Rezoning Petition Review – Charlotte Tree Ordinance

Subject: City of Charlotte – Urban Forestry Rezoning Petition Review Summary

Review Date: August 26, 2021

Rezoning Petition: 2021-094

RZ1.0

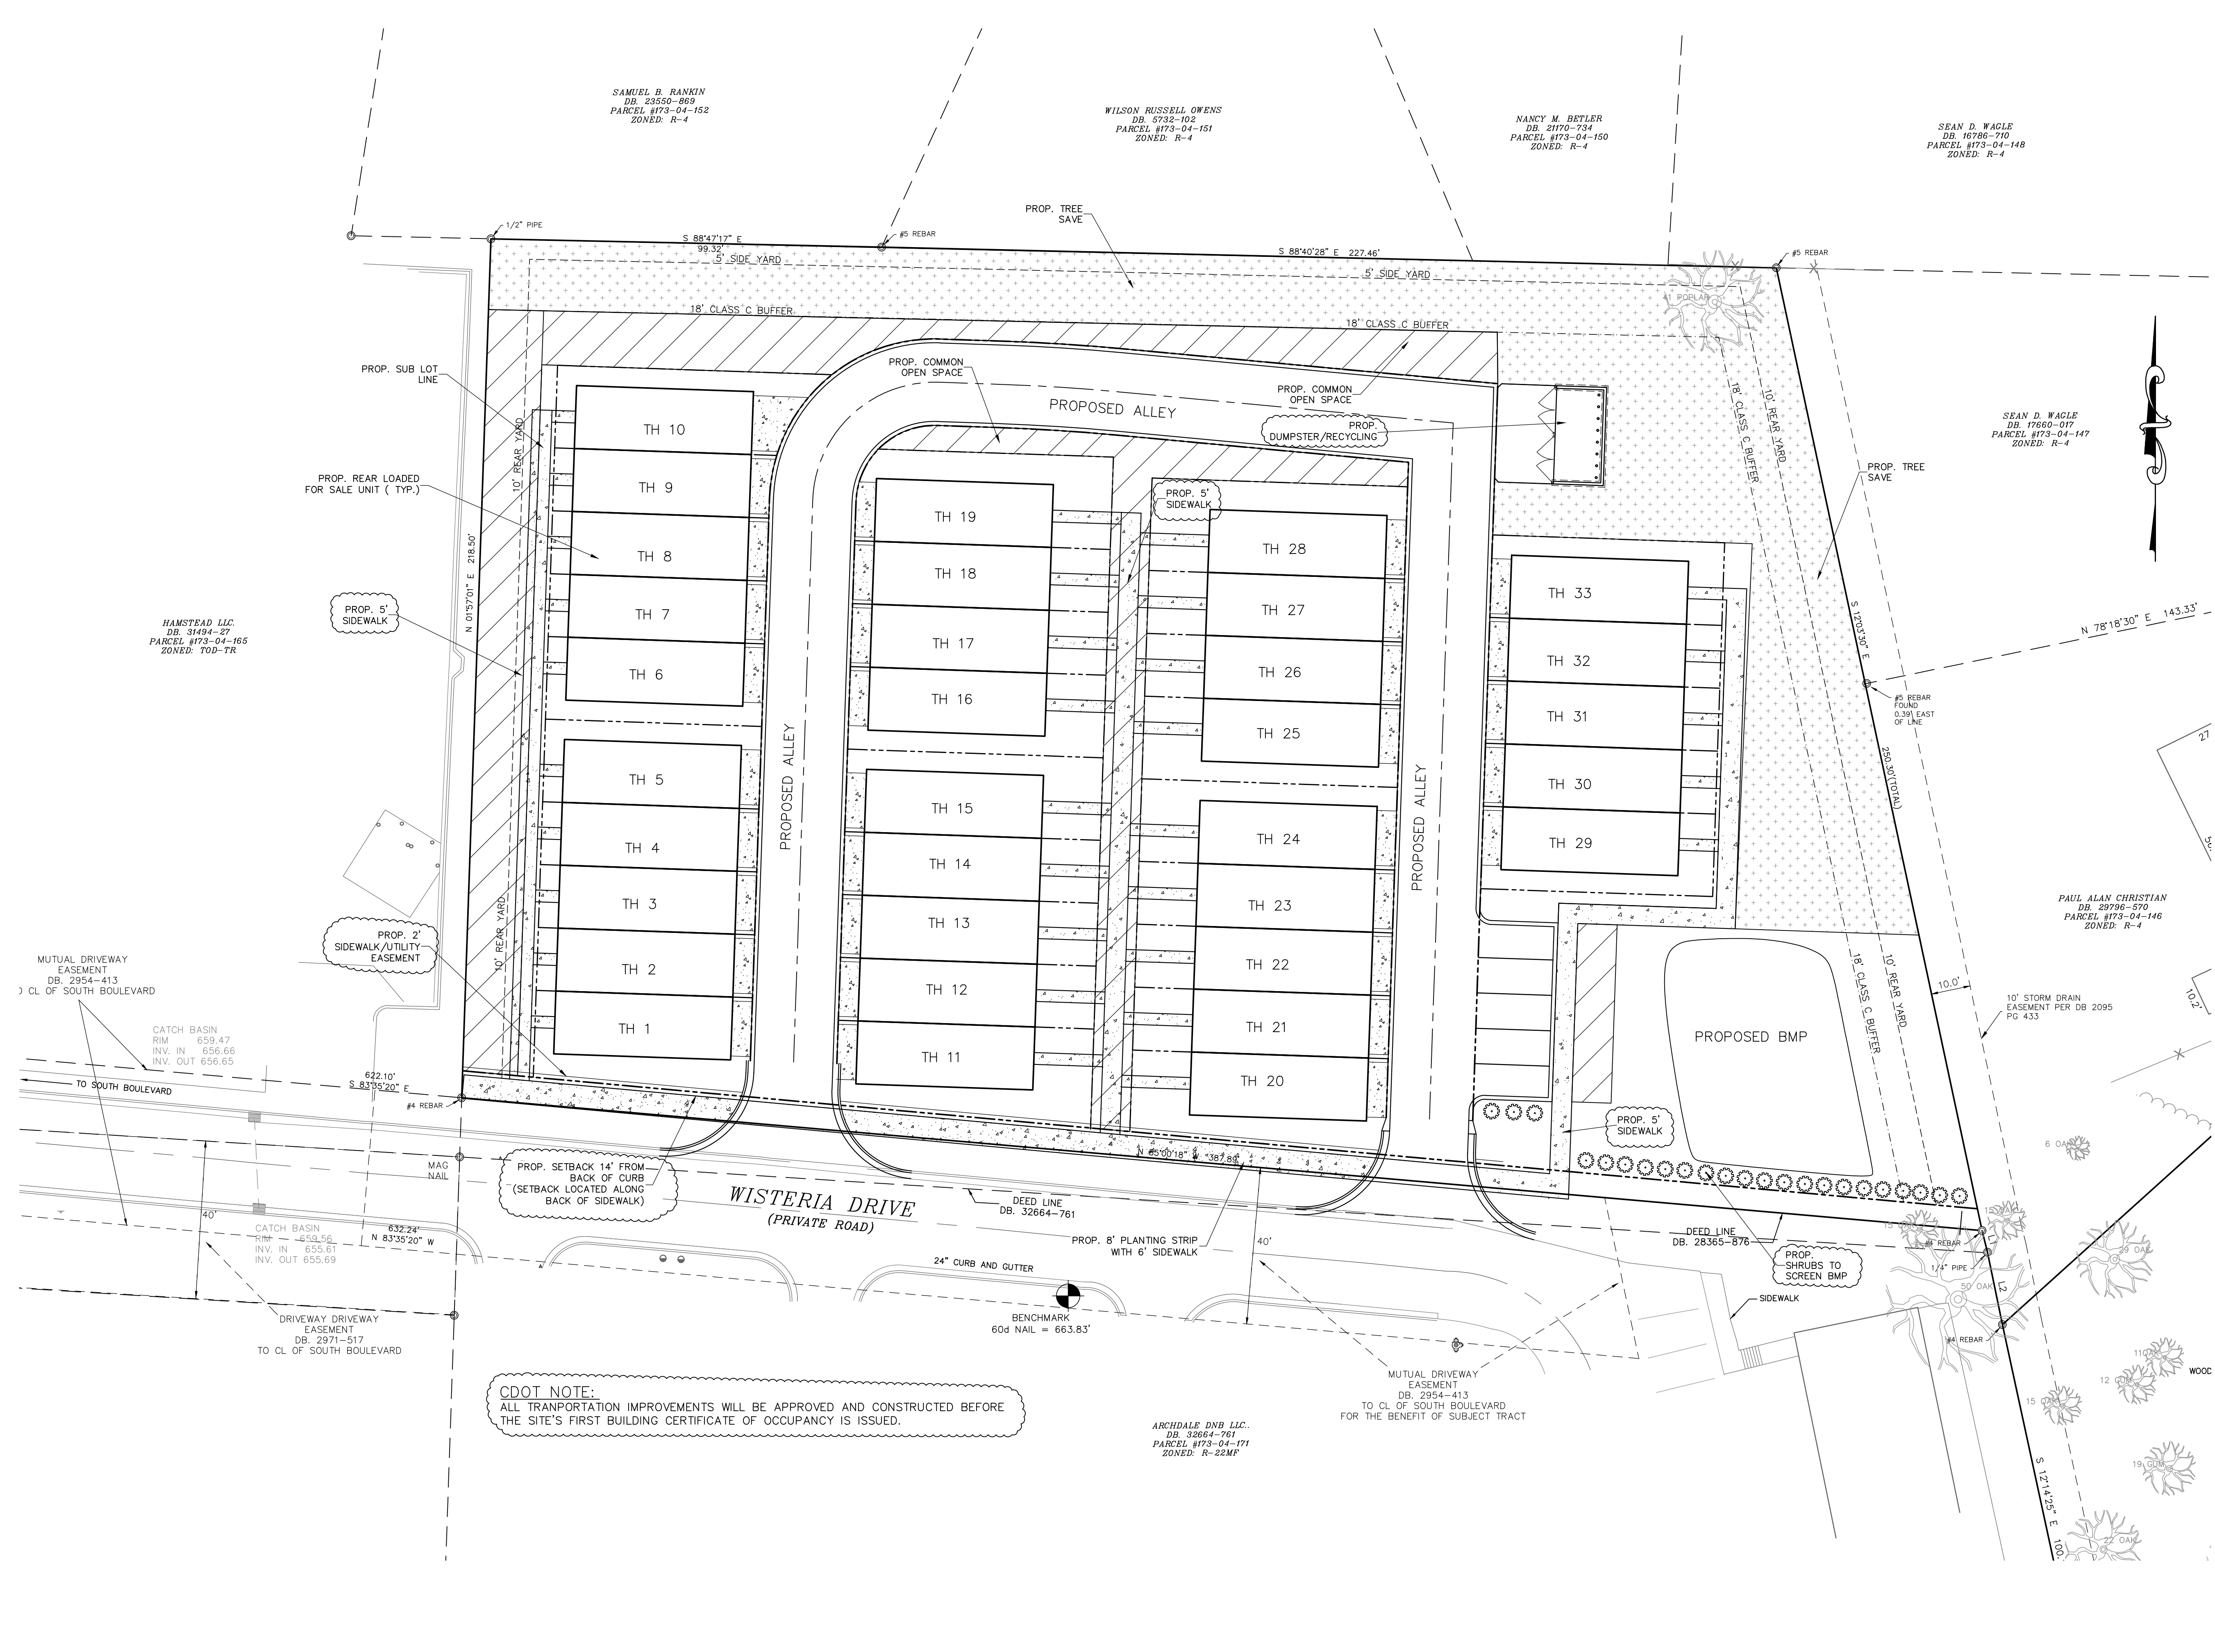
- Conditional rezoning petition submittals shall provide notation referencing how tree save requirements will be met by the site and depict potential tree save areas.
